Recommendation Report for Planning Permission for Works or Extension to a Dwelling

REF NO: BE/149/21/HH

LOCATION: 37 Central Avenue
Bersted
PO21 5HT

PROPOSAL: Hip to gable loft conversion with the installation of 1 x rear dormer

PROPOSED SECOND FLOOR PLAN

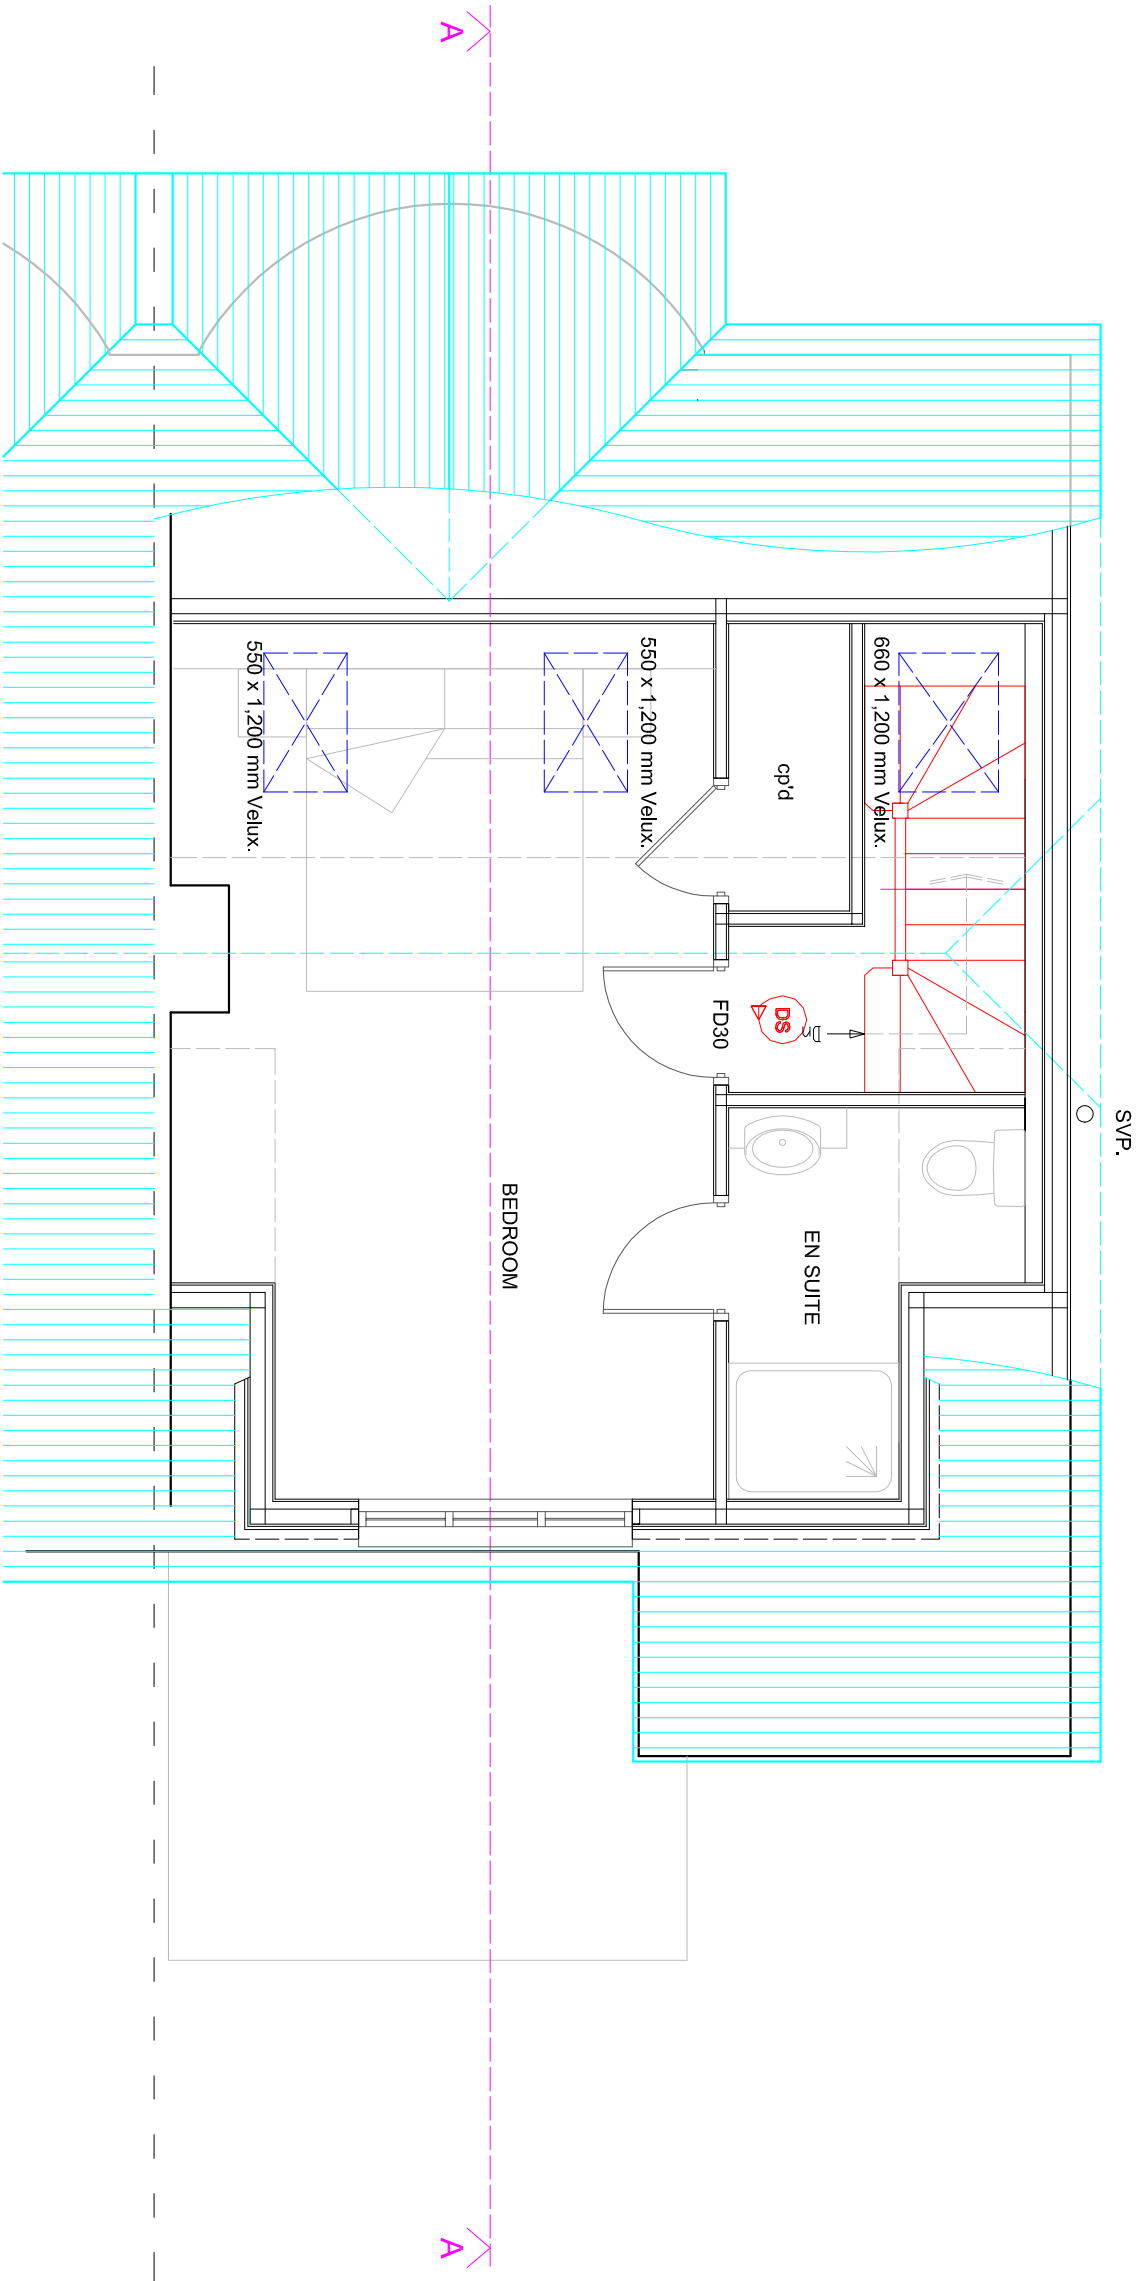
The hip to gable loft conversion will form a new bedroom and bathroom at second floor. There will be three new roof windows to front (south) second floor roof plane.

PROPOSED ELEVATIONS

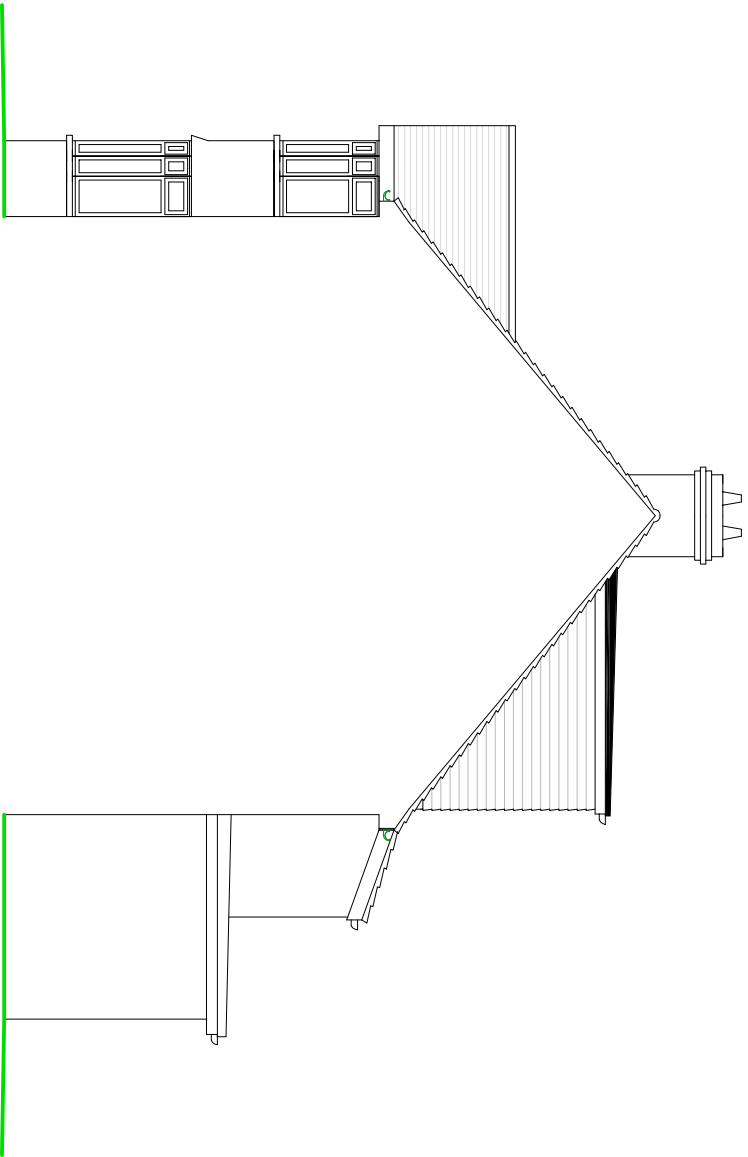
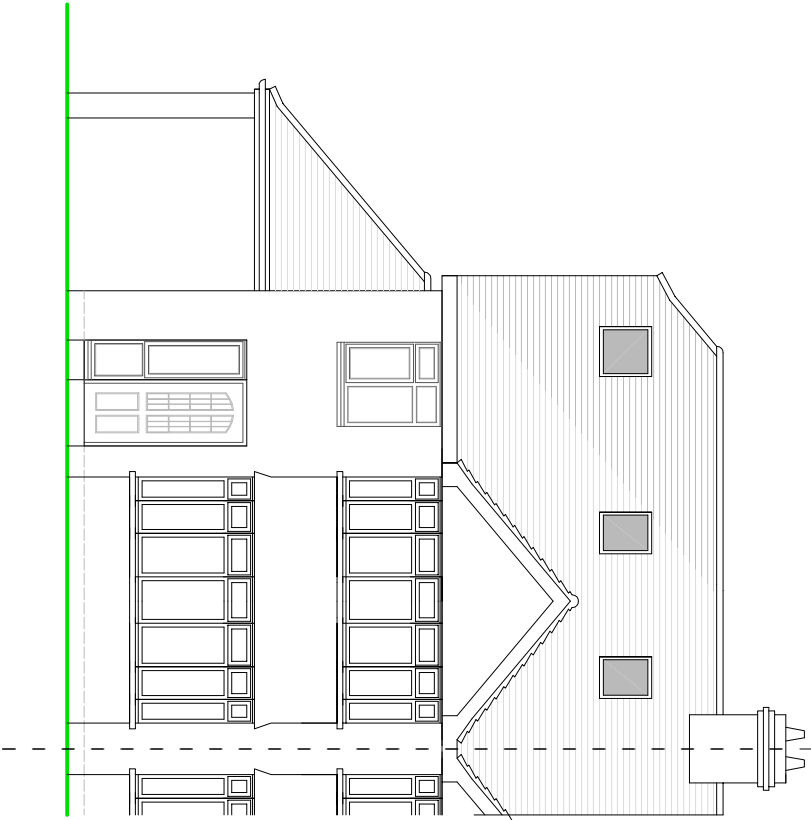
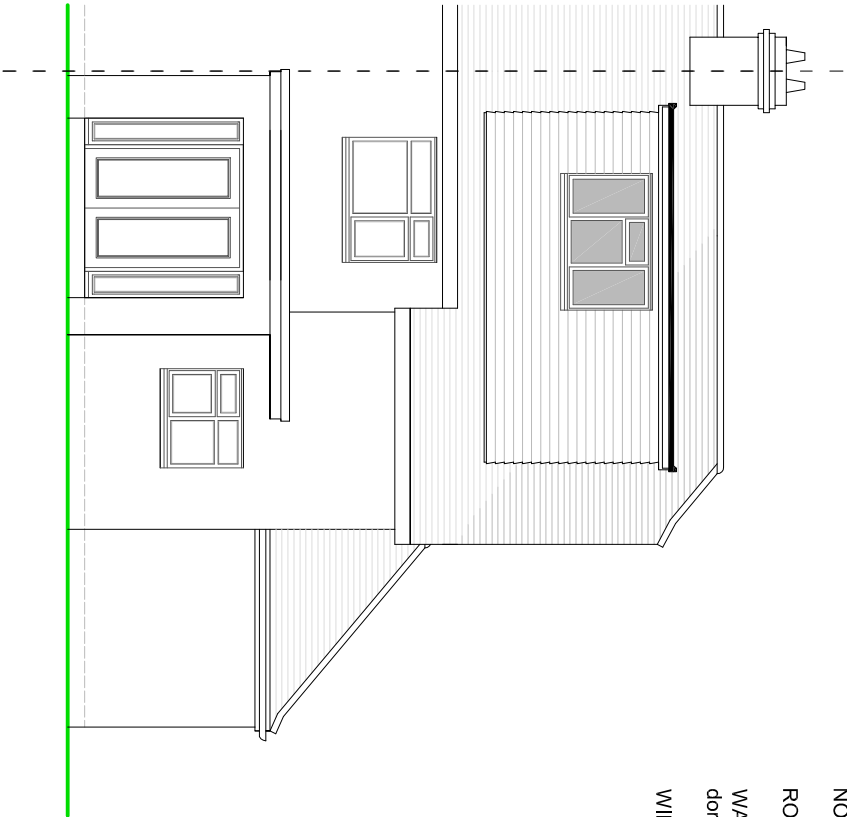
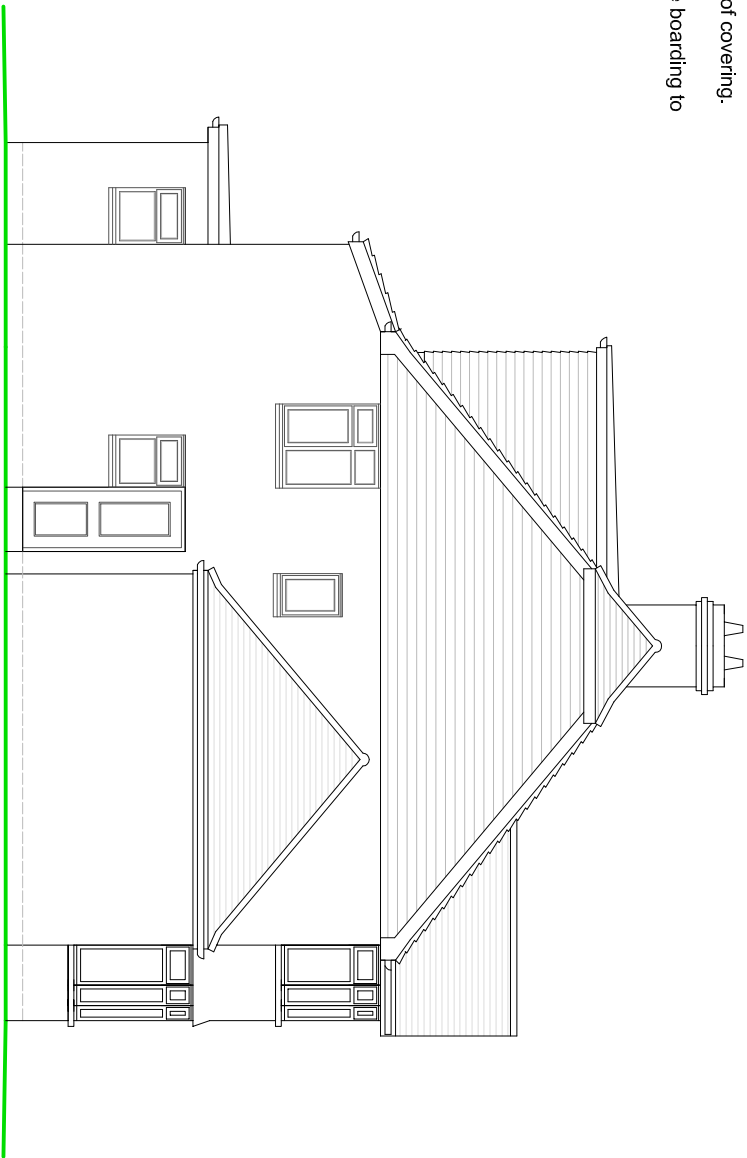
The gable end to front is highly visible from street scene. However the gable end design integrates with existing dwelling and does not adversely impact character of surrounding area due to there being a mix of designs within street scene so complies with policy D DM1 of the Arun Local Plan.

The new dormer will be sited to the rear (north) elevation at second floor. It will measure approximately 4.80m wide x 3.25m deep x 2.50m high. It will contain one window (2 window panes) to rear (north) elevation.

It states roof extensions should be located in discreet positions on rear elevations wherever possible. Whilst the proposal to front does not comply, it does not detract from the character or appearance of the dwelling or wider area so is acceptable.

It states small scale dormer windows with pitched roofs are favoured over large, flat box-shaped designs. Whilst the large box shape dormer to rear does not comply, a similar one could be done under Permitted Development dependent on the size and materials used so is acceptable.

It also states that when extensions include roof lights, these should maintain the privacy of neighbouring properties. Rooflights should be used sparingly, discreetly, and centred on the roof. Rooflights will not generally be permitted on the principal roof elevation (usually the front elevation). Whilst the rooflights to

front do not comply they are set back from front boundary and are symmetrical in design so do not cause adverse harm.

The proposed materials seem to match existing dwelling and consist of plain concrete roof tiles to match existing, walls of plain tile hanging or cement based 'New England' style boarding to dormer cheeks and gable end, and white UPVC doubled glazed windows and doors so complies with policies D DM1 and D DM4 of the Arun Local Plan, ES1 of the Neighbourhood Plan and the Design Guide.

The hip to gable loft conversion will be no add no additional height to the roof ridge line but the change of roof shape from hip to gable end will affect neighbouring amenity to west no 39 Central Avenue. However there is around 2.60m retained to the western boundary and 3.87m to the neighbouring property so the impact on overshadowing or overbearing effects is reduced so is acceptable.

The new dormer to rear (north) at second floor will increase risk of overlooking to neighbouring properties to rear (north) however large gap of around 16.1m retained to rear boundary and existing windows to rear first floor it will not cause adverse additional impact on overlooking to neighbouring amenity so complies.
